Application number: 2019/91327	
What is the application for?:	Reserved matters application pursuant to outline permission 2017/90207 for erect
Address of the site or building:	Thongsbridge Mills, Miry Lane, Thongsbridge, Holmfirth, HD9 7RW
Postcode:	HD9 7RW

8_Access Road Elevation 1: 200

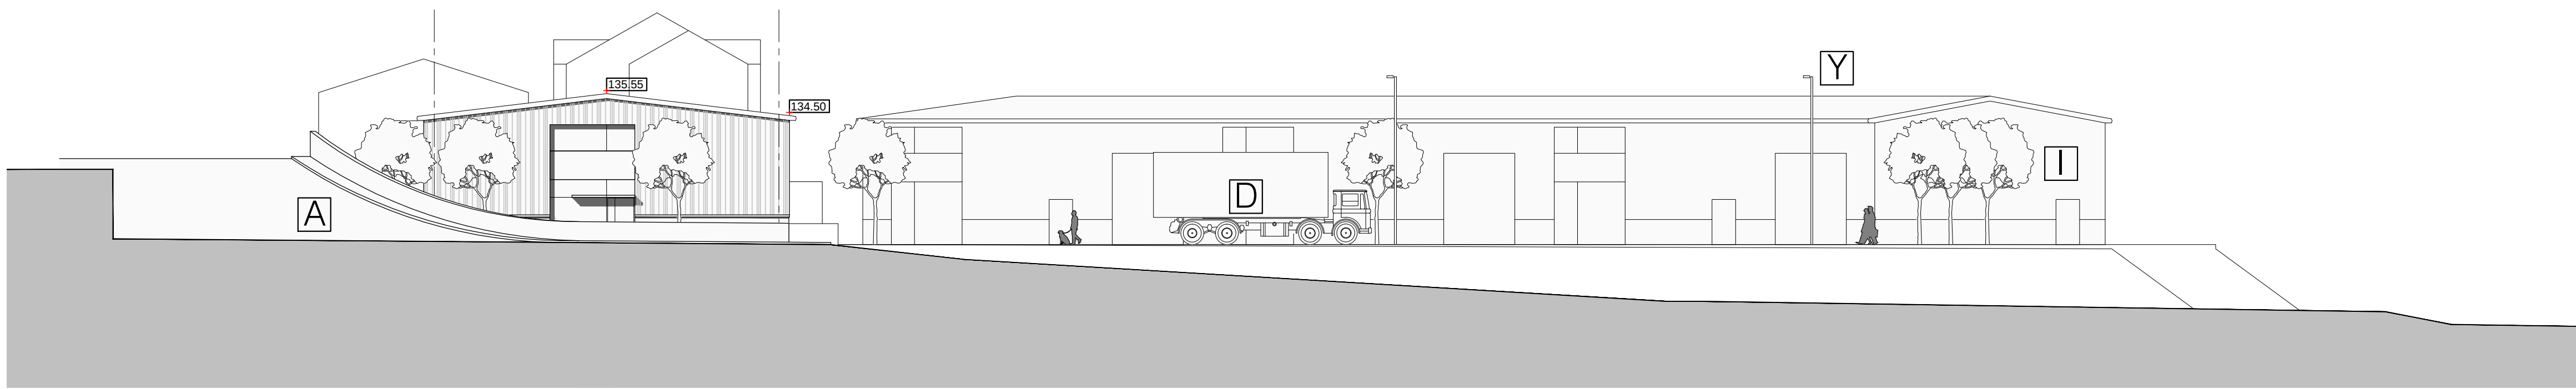
The proposed development in its current form will have a serious adverse impact on our residential amenity and will have an overbearing impact

and the scale and height of the proposed building.

The proposal will have an overshadowing impact on our living accommodation and from early morning to afternoon. Our natural light will therefore be seriously compromised for at least 6 months of the year.

To summarise, the proposal, will have a considerable overbearing negative impact This will seriously blight and have a huge negative impact on our day to day living and well-being.

We therefore respectfully request that Kirklees Planning give full consideration to our concerns regarding the current proposal. We would expect as a minimum that further thought is given to the layout and scale of the proposed development, so as to have considerably less impact on our lives.
